Ribble Valley Borough Council
Housing & Development Control

Application no: **3/2024/0033**

Address: **1 Dewhurst Farm Holiday Let Longsight Road Langho BB6 8AD**

Proposal: **Change of use from holiday let to C3 dwelling with unrestricted residential use.**

SUPPORTING PLAN FOR
THE CHANGE OF USE.

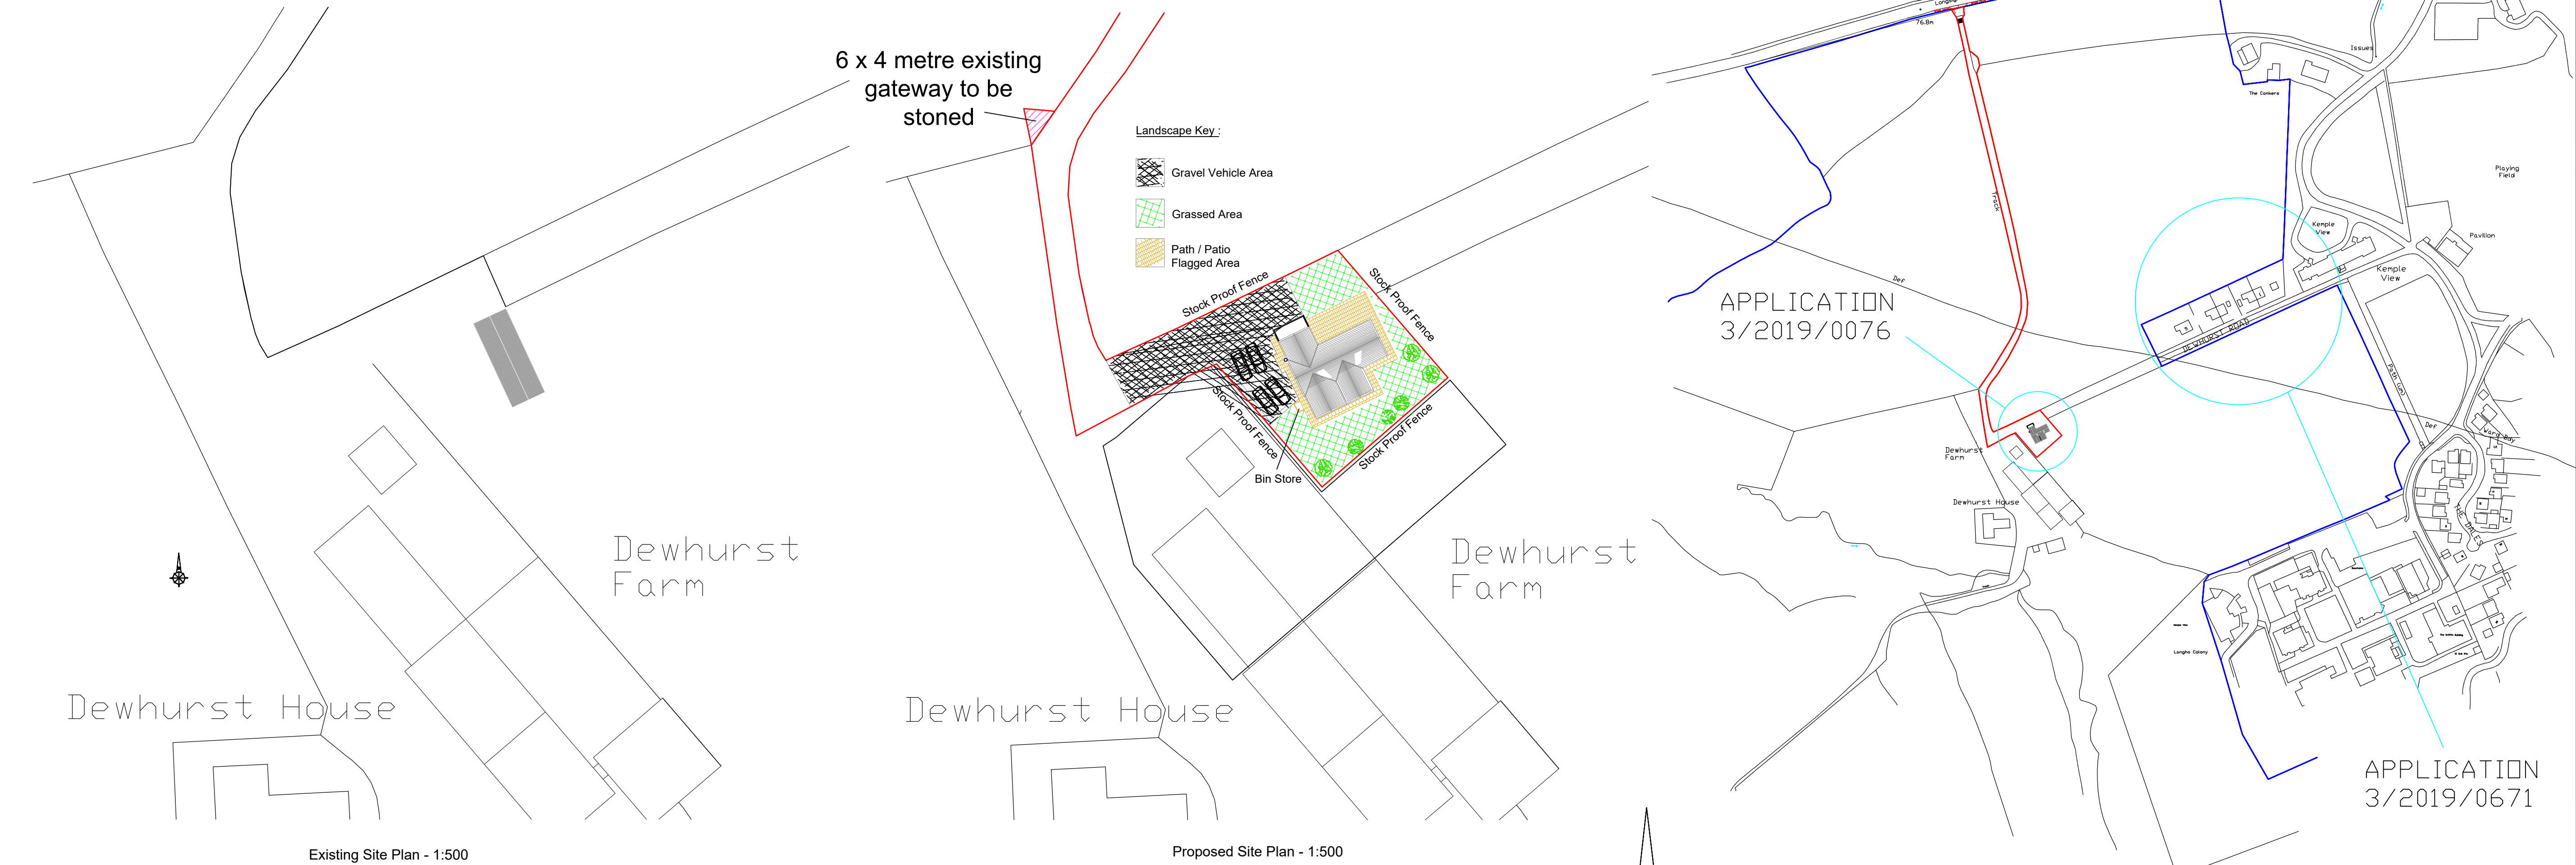
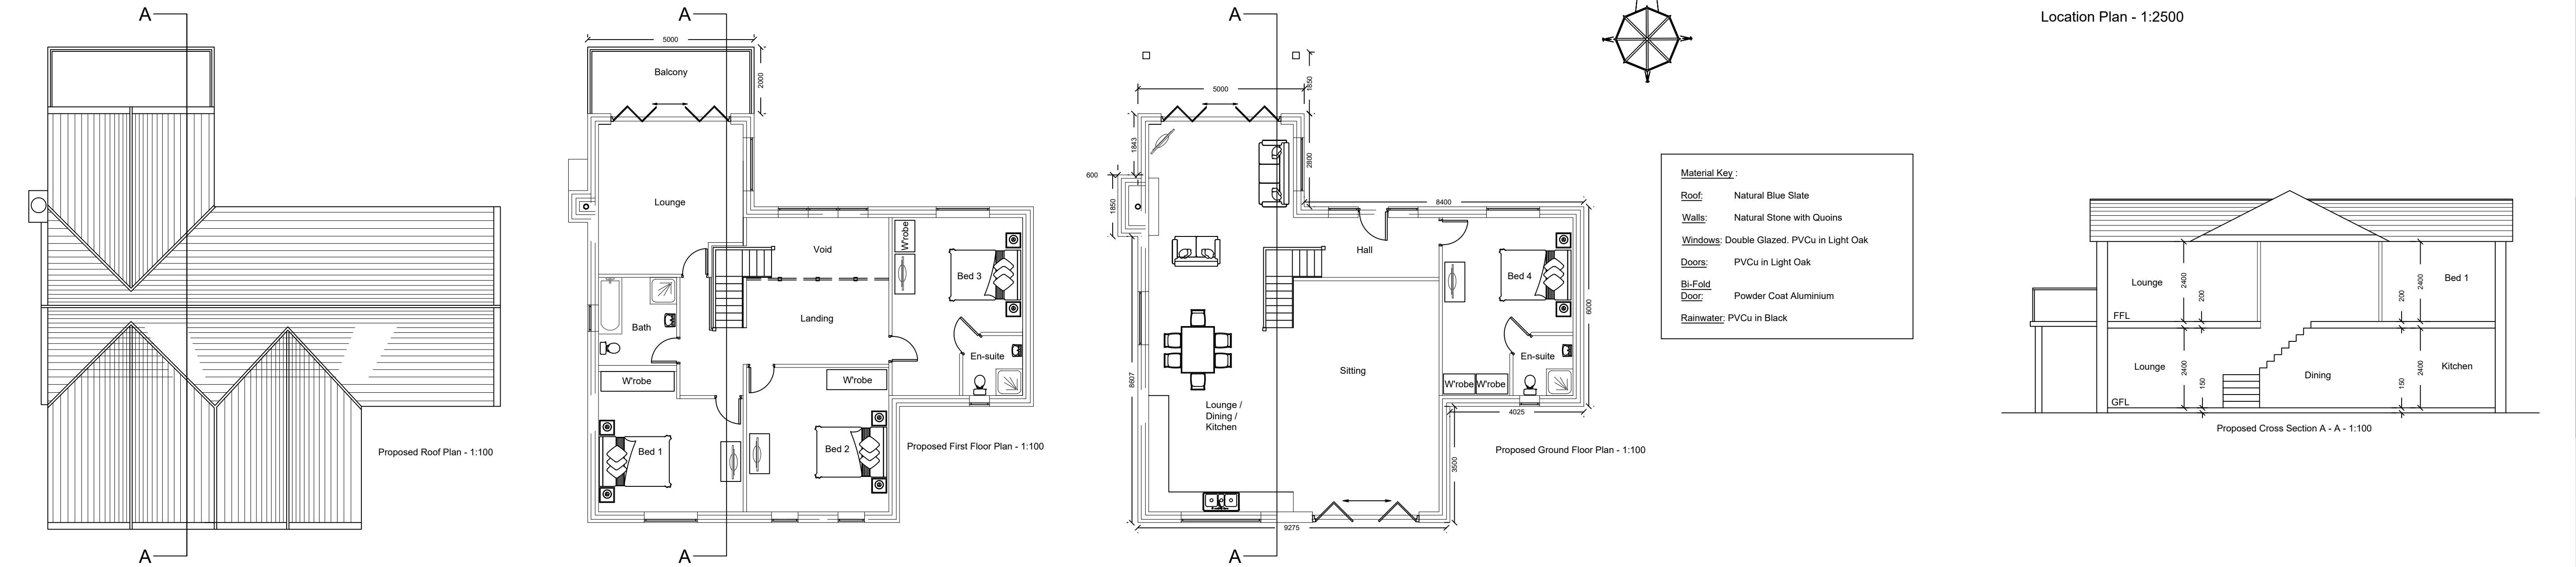
The LHA have reviewed the drawing titled "Supporting Plan for Change of Use" and are aware that the parking arrangements comply with the LHAs parking guidance as defined within the Joint Lancashire Structure Plan.

The LHA will however condition, following the change of use that a minimum of one space provides access to an electric vehicle charging point and that the dwelling has access to a cycle storage facility.

1. The development hereby permitted shall not be occupied until such time as the parking and turning facilities have been implemented in accordance with drawing titled "Supporting Plan for Change of Use". Thereafter the onsite parking provision shall be so maintained in perpetuity.

2. Prior to the first occupation the dwelling shall have an electric vehicle charging point. Charge points must have a minimum power rating output of 7kW, be fitted with a universal socket that can charge all types of electric vehicle currently.

3. No building or use hereby permitted shall be occupied or the use commenced until a cycle storage plan for the residential unit has been submitted to the Local Planning Authority, in consultation with the Local Highway Authority. These cycle facilities shall thereafter be kept free of obstruction and available for the parking of bicycles only at all times.
